Please upload as correspondence (submission of amended floor plans).

From: Gordon [REDACTED]
Sent: 08 March 2025 09:54
To: Harry Chalk <Harry.Chalk@arun.gov.uk>
Subject: RE: LU/10/25/PL - 78 Wick Street

From: Harry Chalk [mailto:Harry.Chalk@arun.gov.uk]
Sent: 04 March 2025 16:13
To: Gordon
Subject: LU/10/25/PL - 78 Wick Street

Proposed Floor Plan

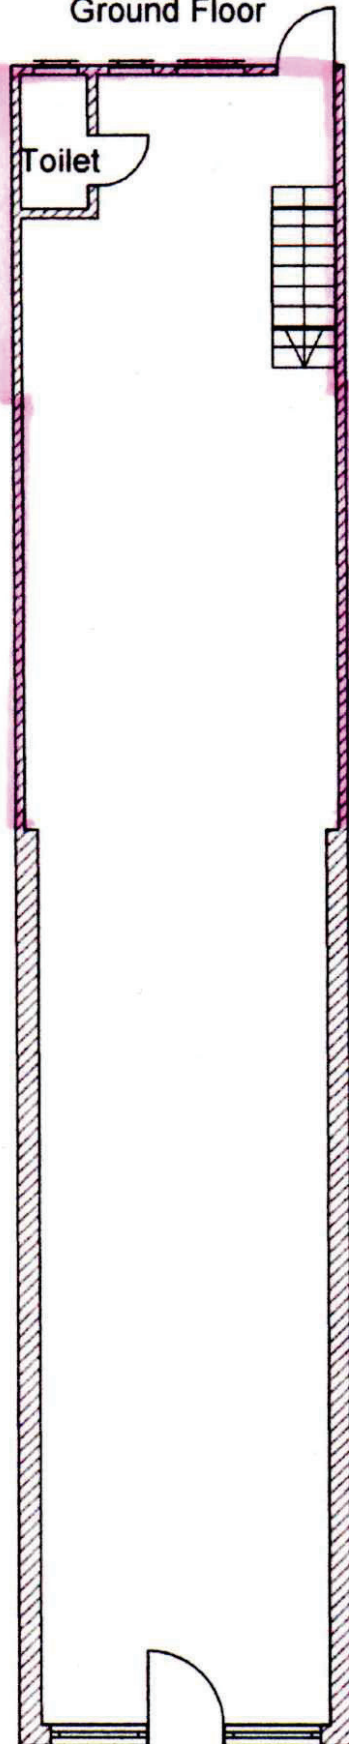
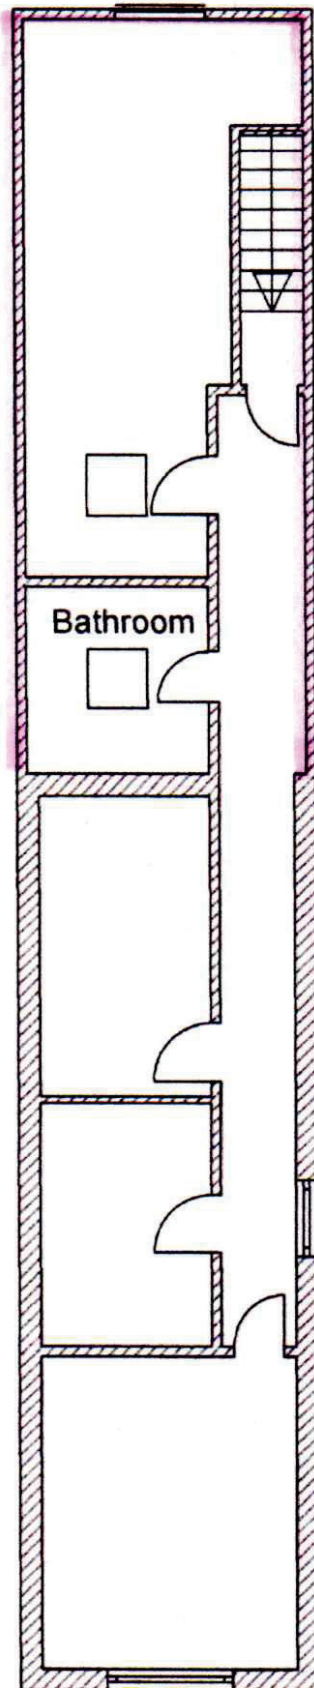
We have concerns that the proposal would potentially be harmful to the residential amenity of occupiers of the first floor of No. 80/80A Wick Street. We are unclear as to the use of the first floor at this neighbouring property and what rooms the first-floor rear openings of the unit serve. We anticipate it may be a first-floor residential flat but have not yet been able to conclude this. Are you aware of the use of the first floor at No. 80/80A? and are you able to provide evidence of this use and what rooms the aforementioned openings serve? We need evidence to accurately assess the resultant impacts on the neighbouring unit.

I do also have some concern pertaining to the overall scale of the proposal and my Line Manager has expressed concerns to this effect in initial conversations, but we are not yet concluded on this matter.

I enclose the updated plan with the additional fire door as requested.
